re: **Response to City Comments**
Proposed Commercial Building Addition
2 Bill Leathem Drive - Ottawa

file: PG5257-MEMO.06

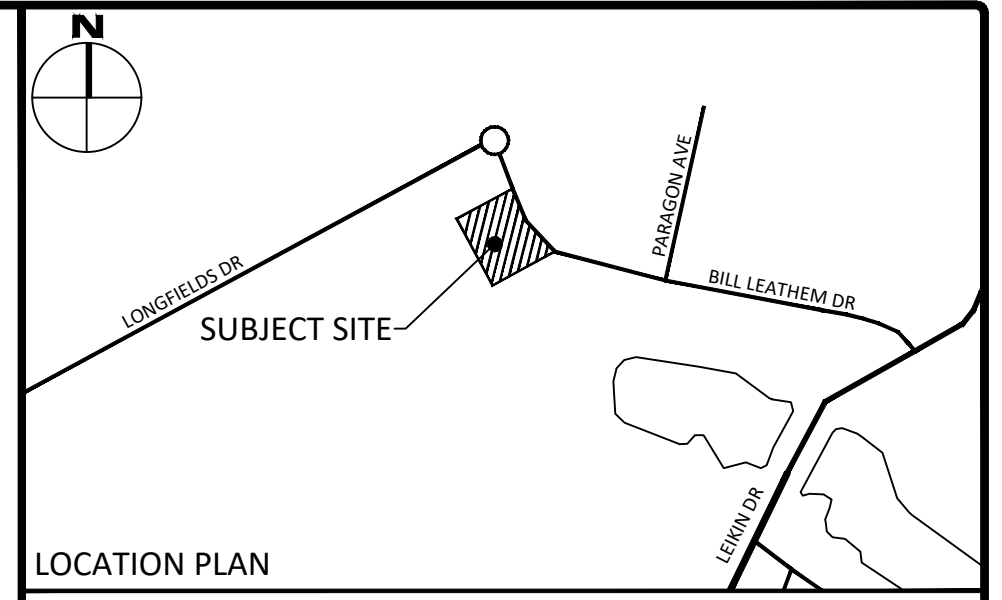
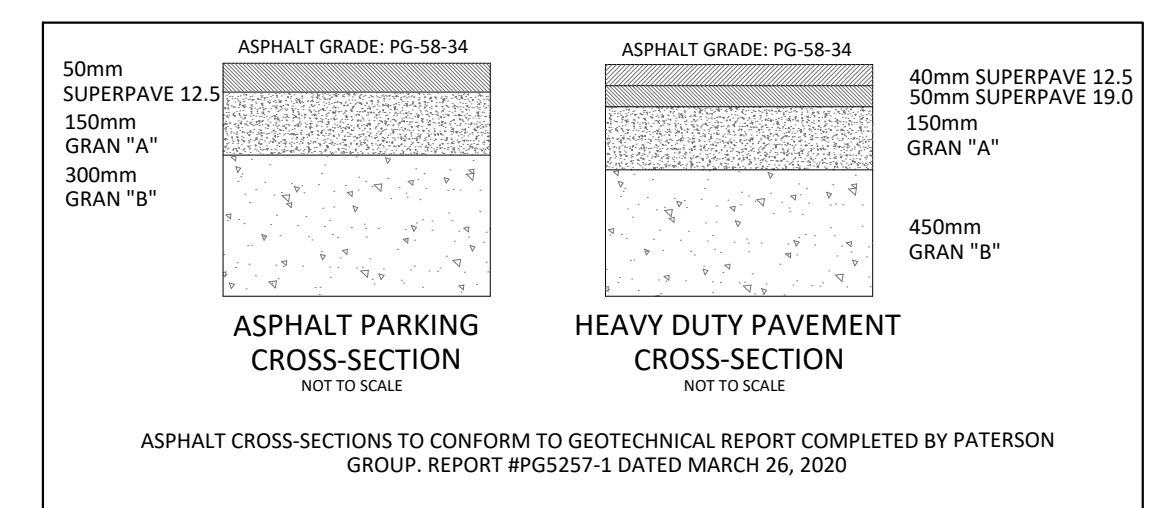
Comment 1.29: *Provide separate memo providing a sign-off confirming that the grading plan and civil engineering design has respected the recommendations of the geotechnical report.*

Response: Paterson completed a grading plan review from a geotechnical perspective for the proposed building addition. The proposed grading is acceptable from a geotechnical perspective. Reference should be made to our geotechnical grading plan review memorandum PG5257-MEMO.05 dated May 24, 2022.
